Application by National Highways for M3 Junction 9 Improvement Scheme
The Examining Authority's written questions and requests for information (ExQ1)
Issued on 25 May 2023

Responses are due by Deadline 2: 15 June 2023

DRAWING TITLE
 FIGURE 8.3 - BIODIVERSITY: INTERNATIONALLY DESIGNATED AREAS FOR BATS - 30km APFP REGULATION 5(2)(a)&(l) DOCUMENT REFERENCE 6.2

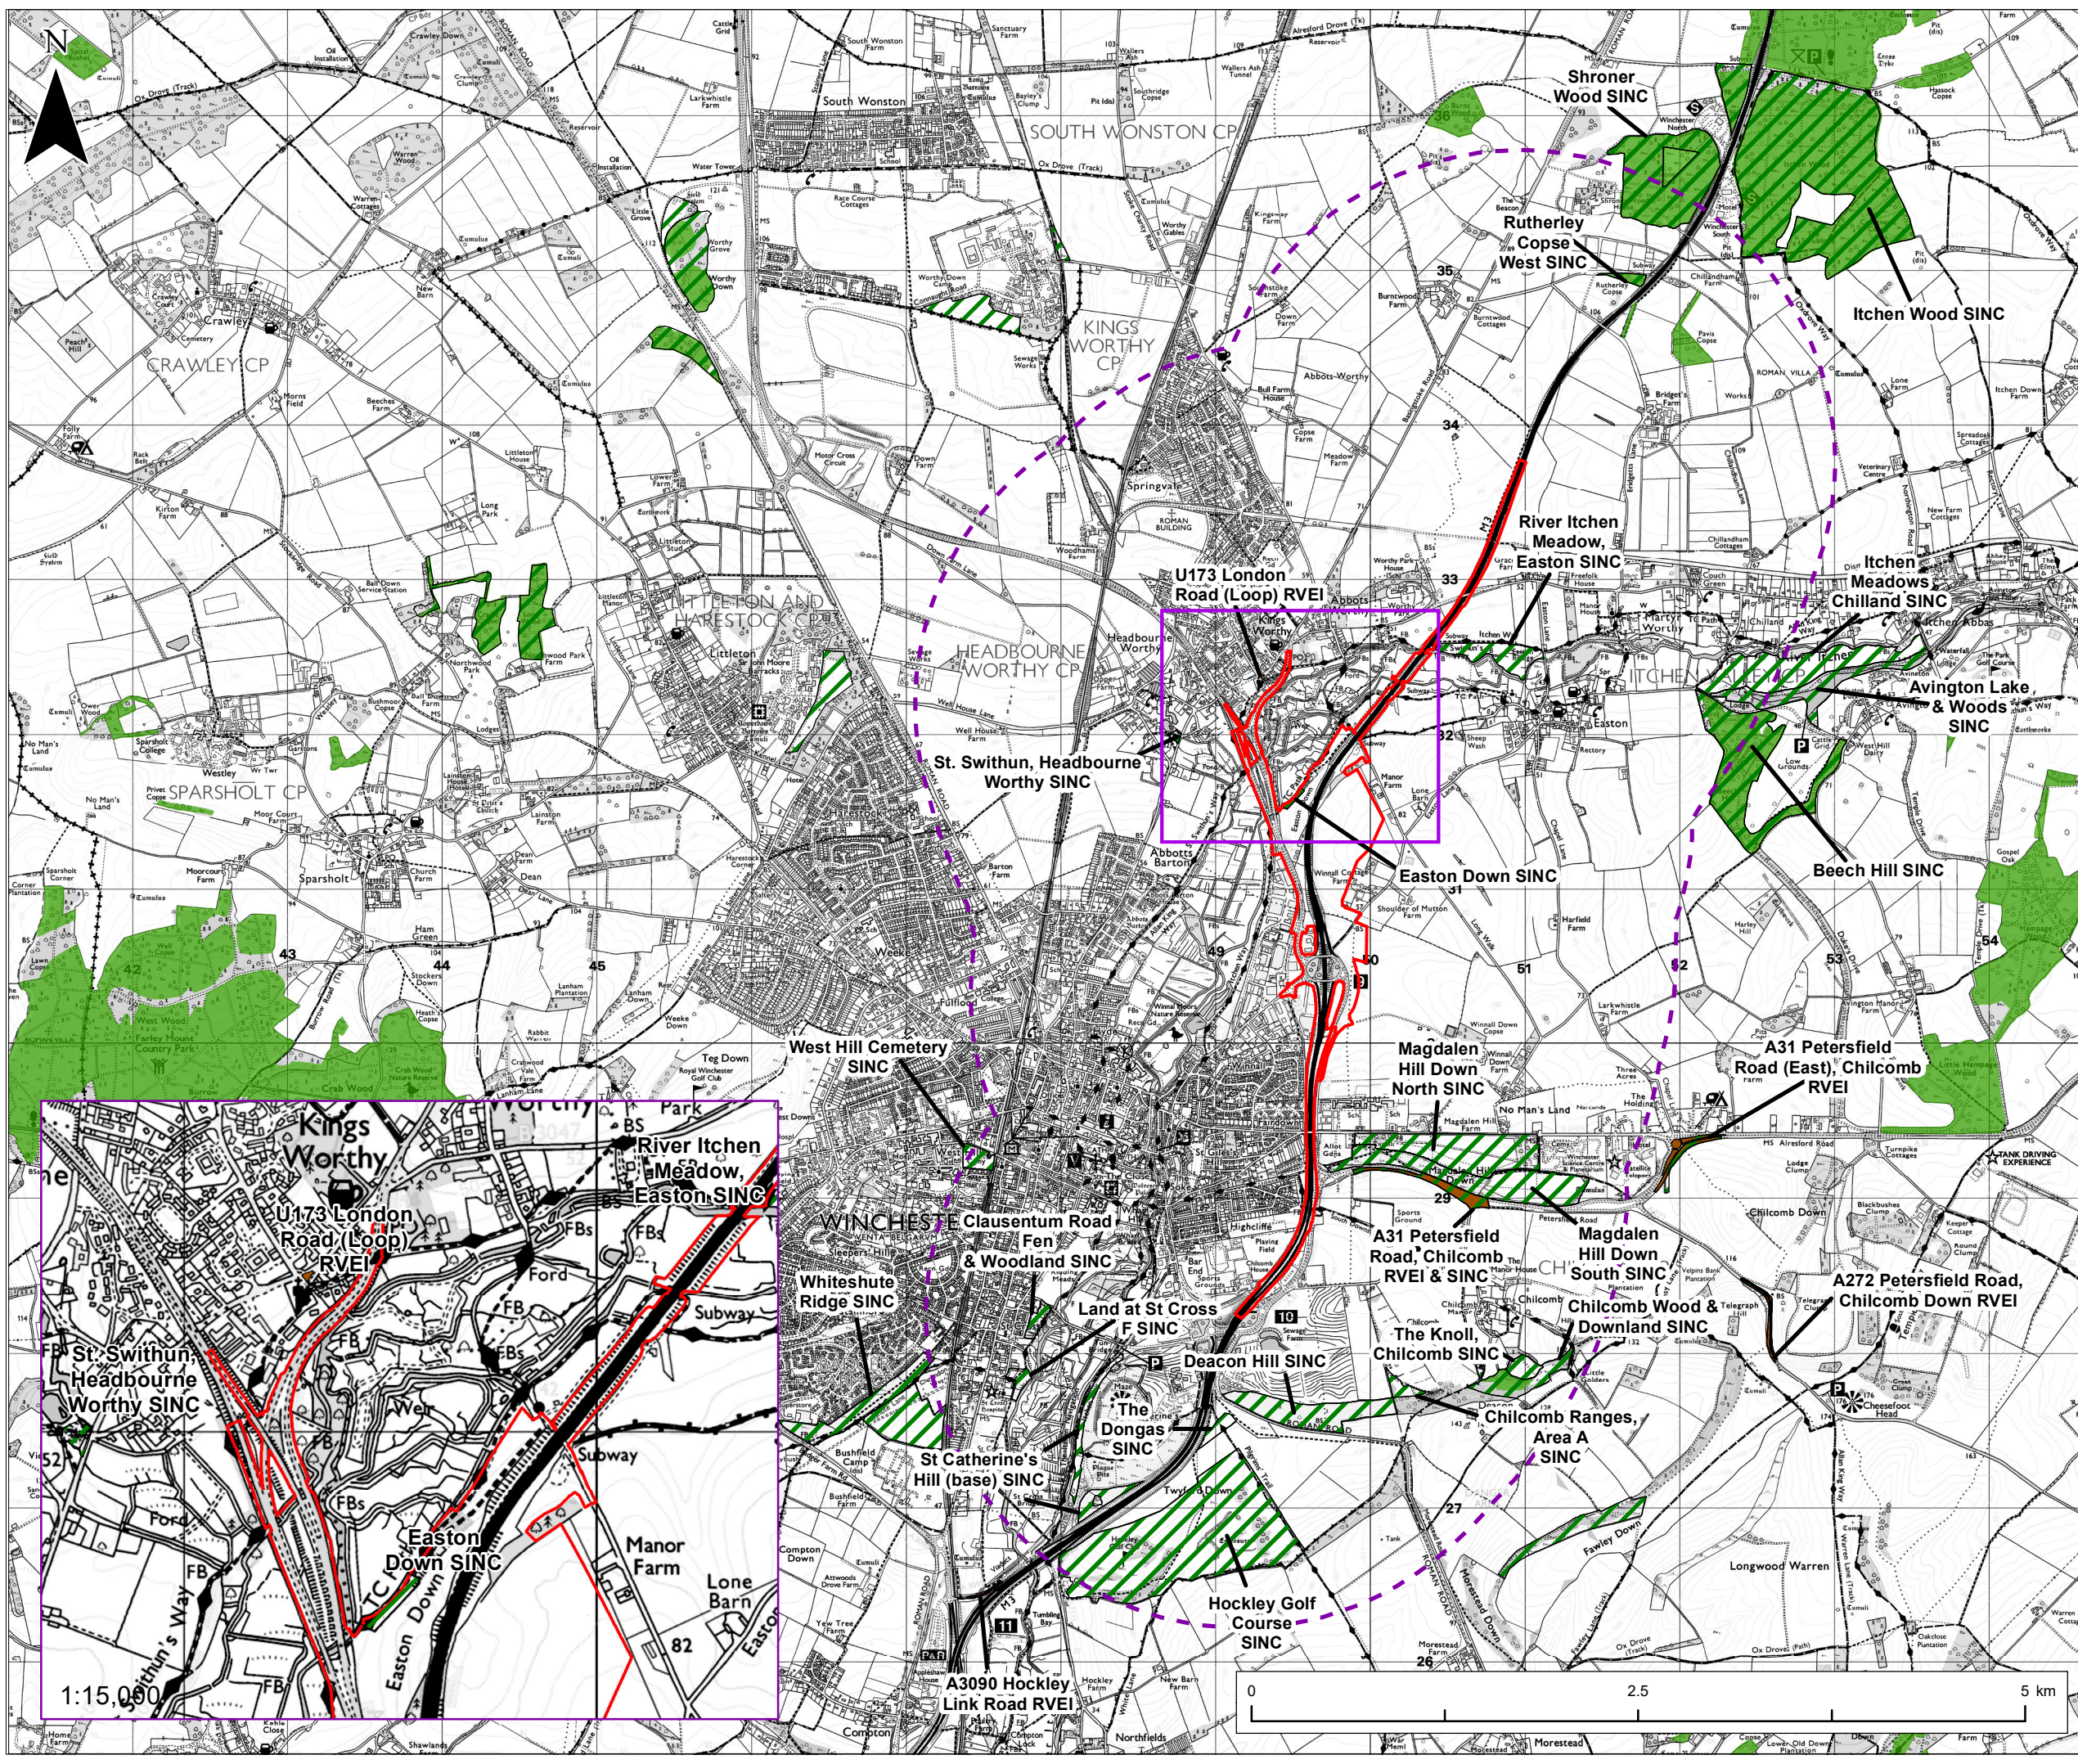
ExQ1	Question to:	Question:
5. Biodiversity, Ecology and Natural Environment (including Habitats Regulations Assessment (HRA))		
Q5.1.1	Figures The Applicant	Figure 8.3 [APP-070] details the SACs within 30km of the application boundary. It is accepted that this is to show Bat related SACs however the key does not define this clearly. Please consider if this is clear and if all SACs within the 30km boundary should be shown or the key definition changed.
Q5.1.2	Consultation The Applicant	Please advise on the current status of consultation with Natural England and the EA. Table 8.1 of Chapter 8 of the ES [APP-049] is a summary of additional consultation since the 2021 statutory consultation and this shows that the last and only consultation was in 2021. There are a number of comments in appendix K which suggest that further feedback and consultation is required with both organisations.
Q5.1.3	Consultation The Applicant	Table 8.1 of Chapter 8 of the ES [APP-049] shows the summary of response from Natural England which stated that badger bait marking survey information was requested. The response suggests this is not yet concluded and information will be provided in the relevant licence application. As this request was in 2021 can the Applicant confirm that these surveys have been undertaken in the intervening period and the results have not impacted on the assessment of impact?
